| Application number: 2023/90696   |                                                     |
| What is the application for?:    | Erection of detached dwelling                       |
| Address of the site or building: | adj, 2, Scopsley Green, Whitley, Dewsbury, WF12 0NF |

Site_Plan
1:200

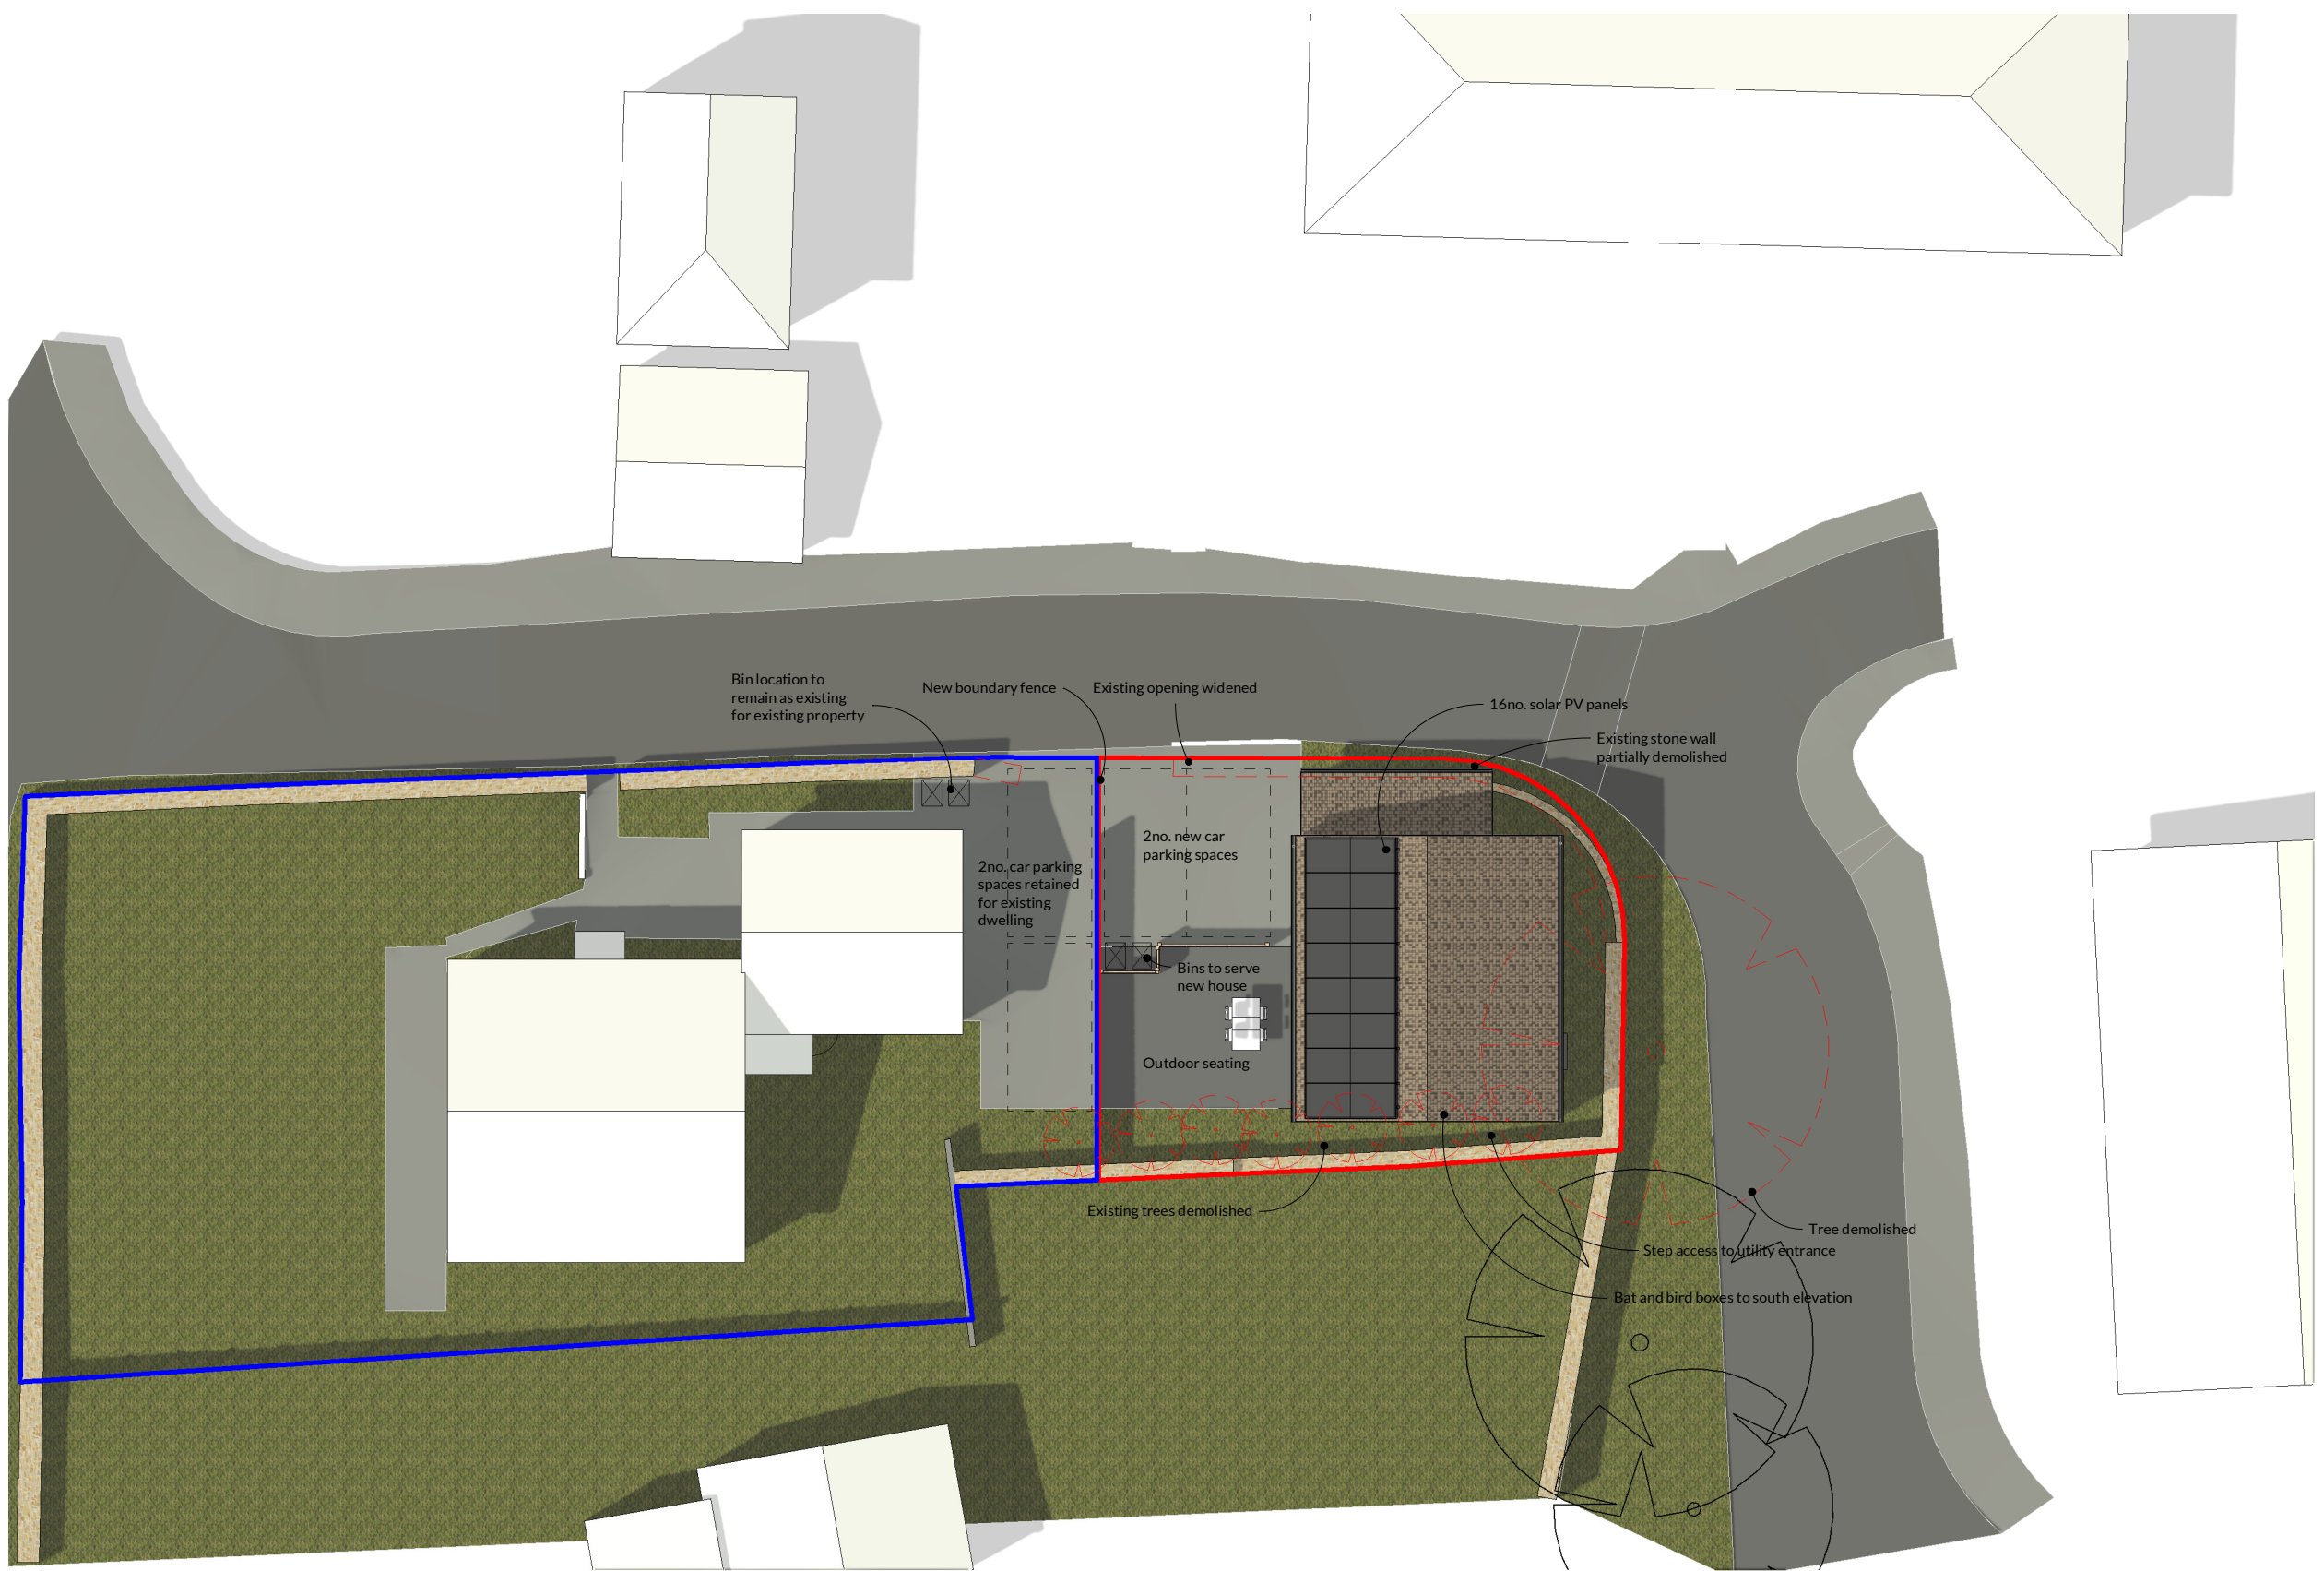
| I am very much unhappy about the proposed plans for the 2 story detached. The parking will cause much distress for most residents living on the lane. Also I don't want to see the tree get demolished. |     |
